From: Graham Evans
Sent: 17 February 2012 09:36
To: Planningecons
Subject: FW: Planning Consultation on: BR/319/11/

APPLICATION NO: BR/319/11/

Registered: 10-FEB-12
Site: 206 London Road Bognor Regis PO21 1AX
Address:

Description of Works: Change of use from residential dwelling (C3 dwelling house) to ground floor chiropractors (D1 non-residential institution) with 1st floor residential accommodation to include demolition of existing garage/store & erection of single storey extension

sheet 3 of 4

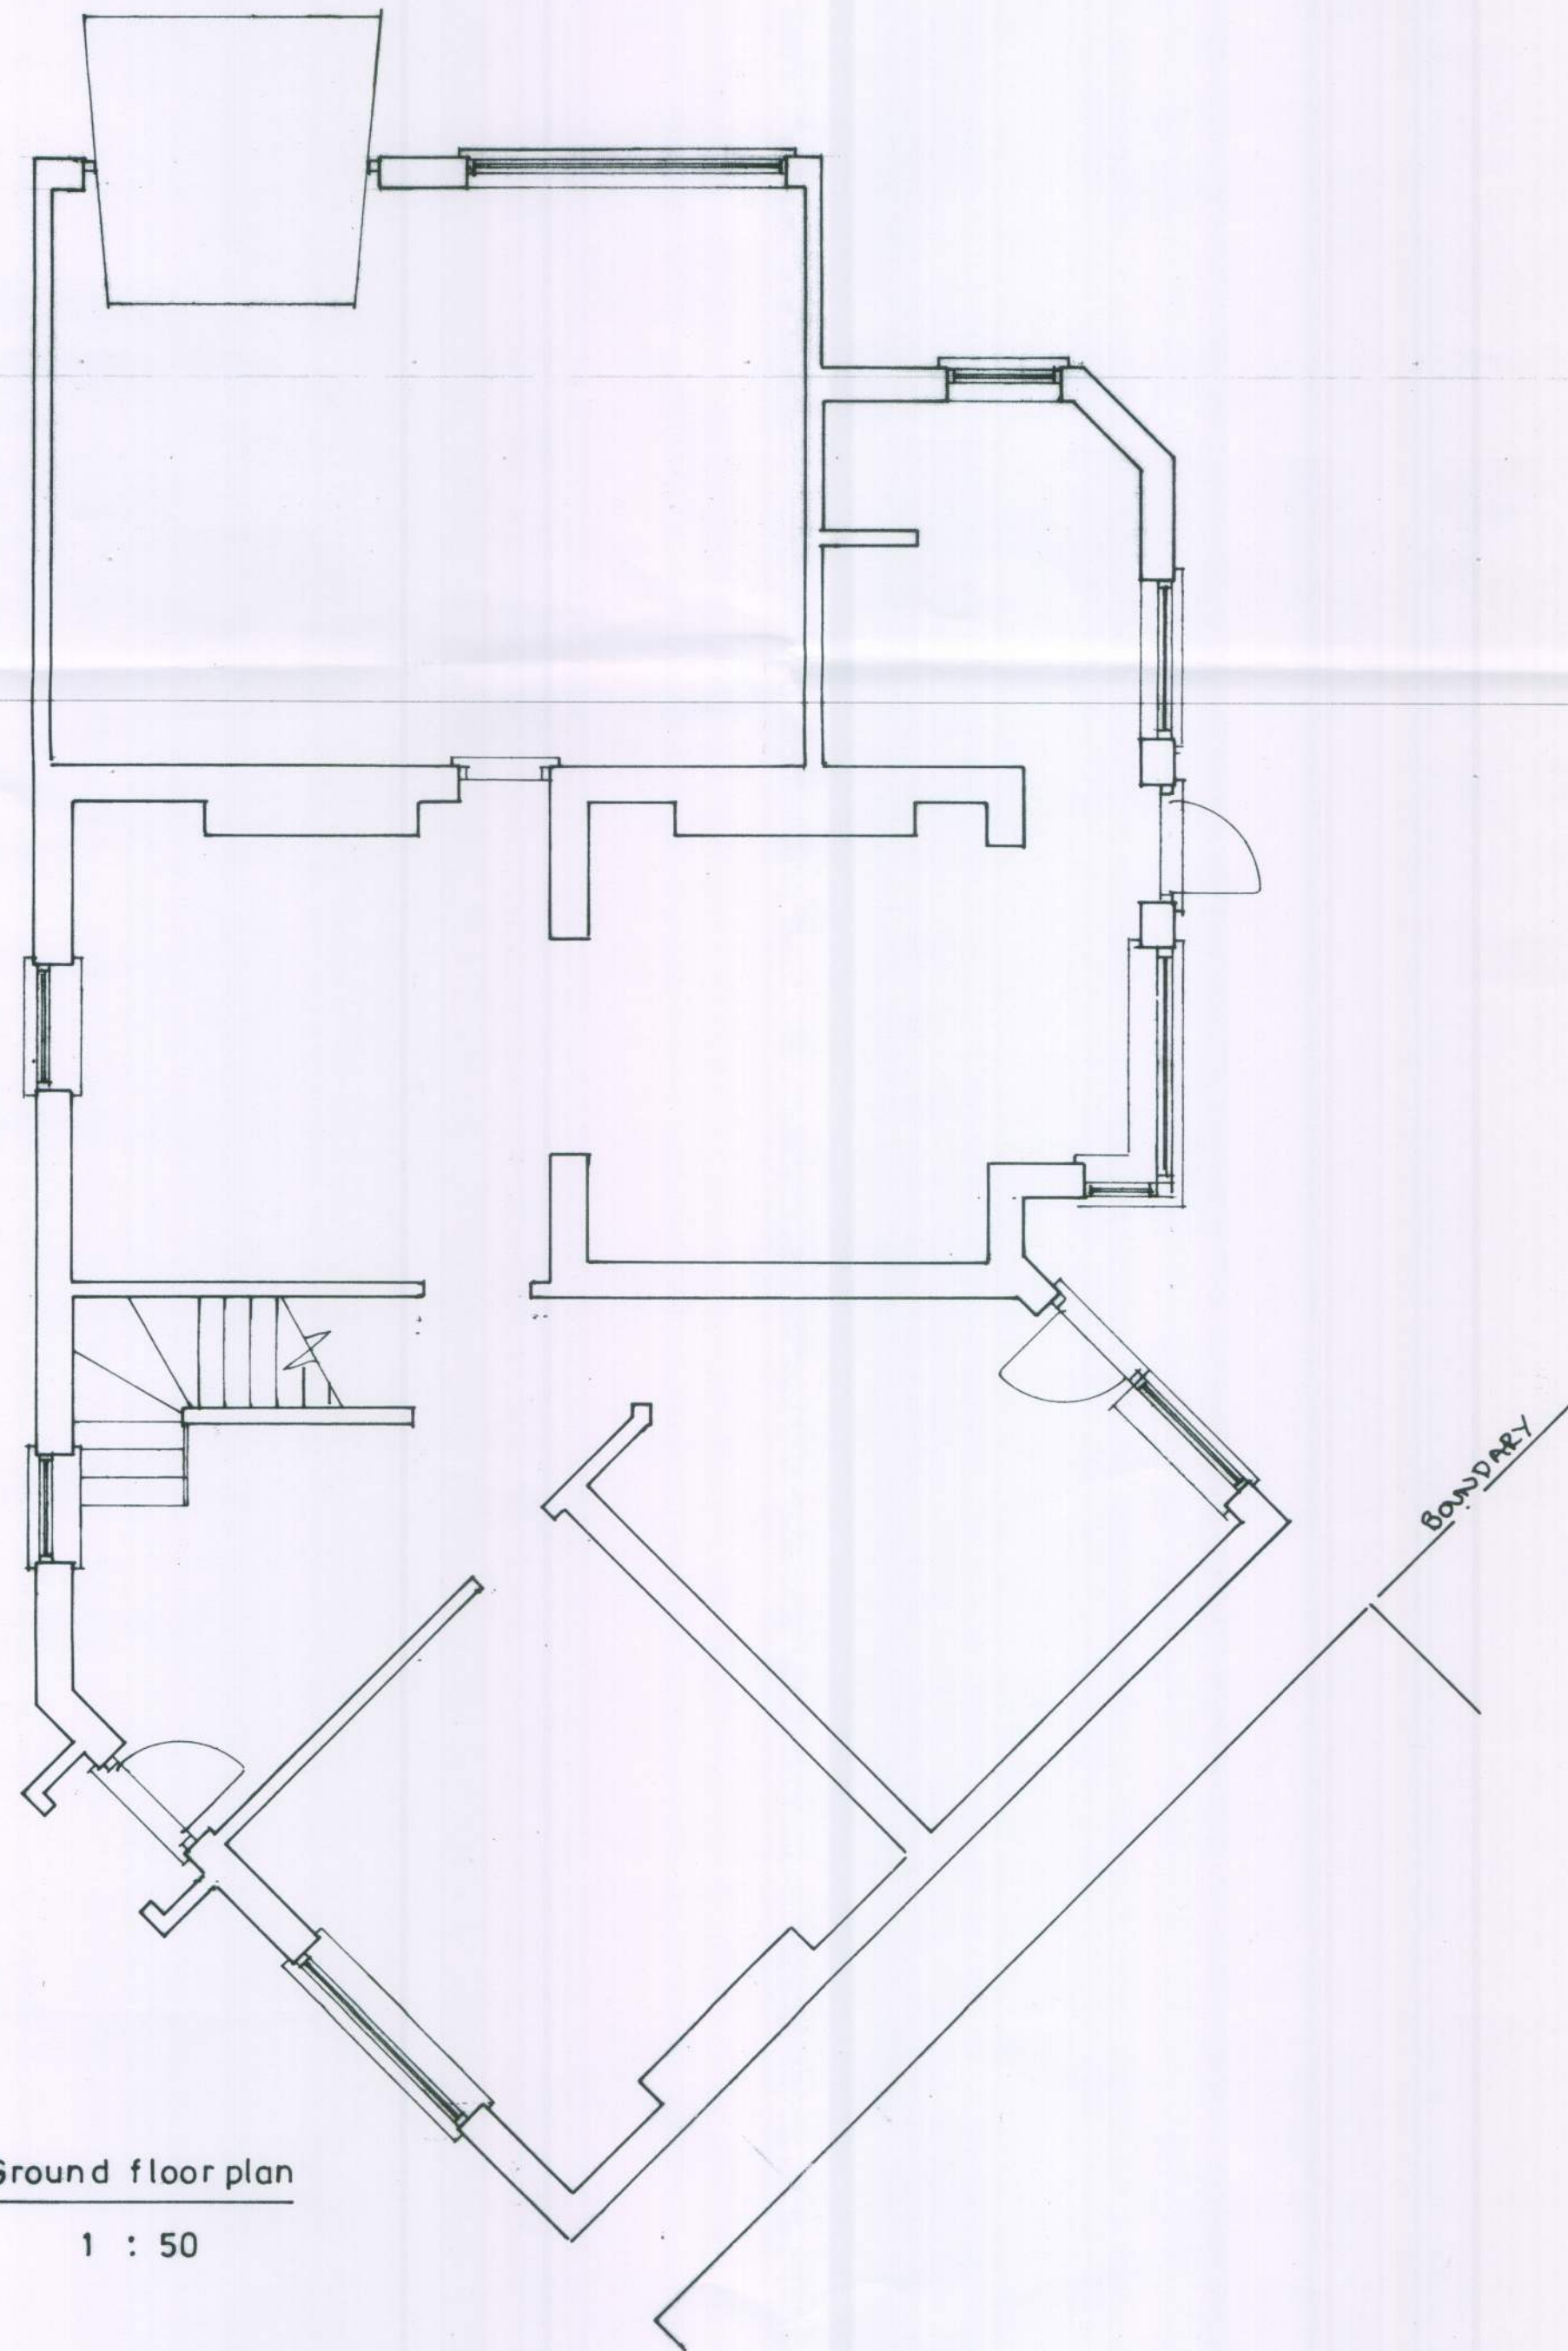
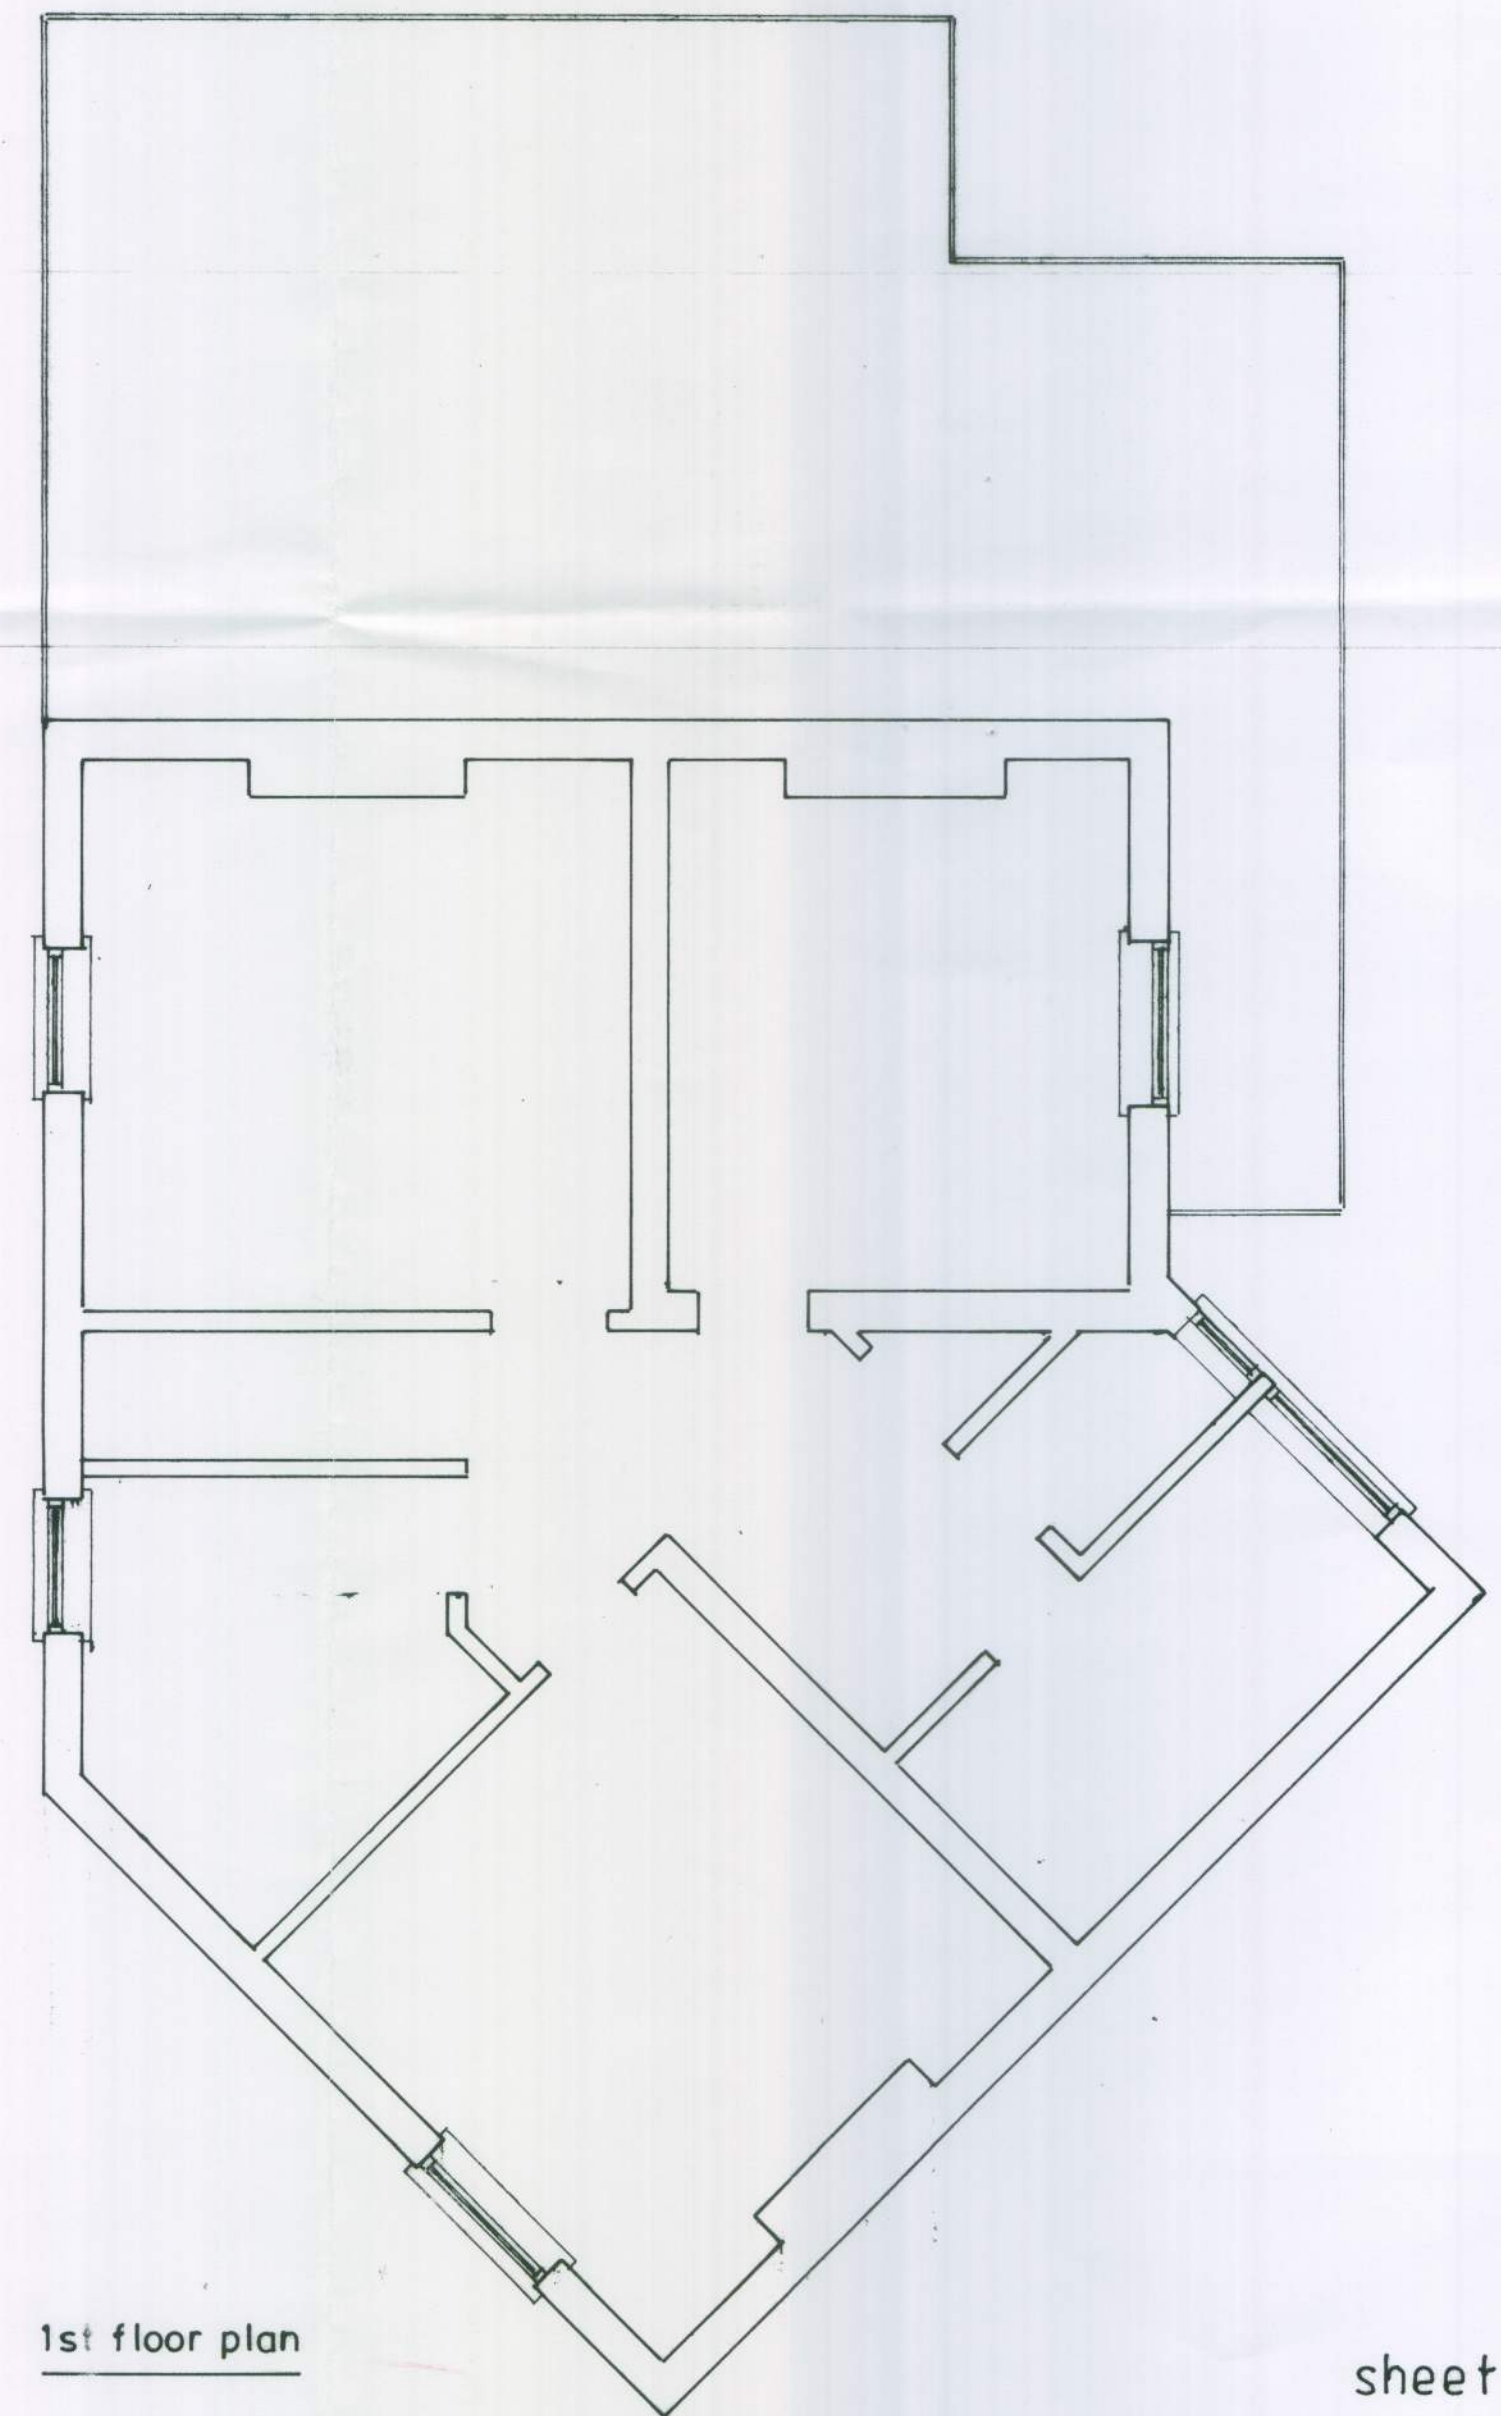
There is potential for noise from the proposed ground floor commercial use to impact upon the residential use at first floor level if this is in separate occupation. The significance of this impact will depend upon the hours of operation (proposal to operate Sundays & B/H's noted in the application), noise produced by activities on the ground floor, and the structure of the floor ceiling partition (no information available). The partition should at least conform to Building Regulation standards for insulation between dwellings.
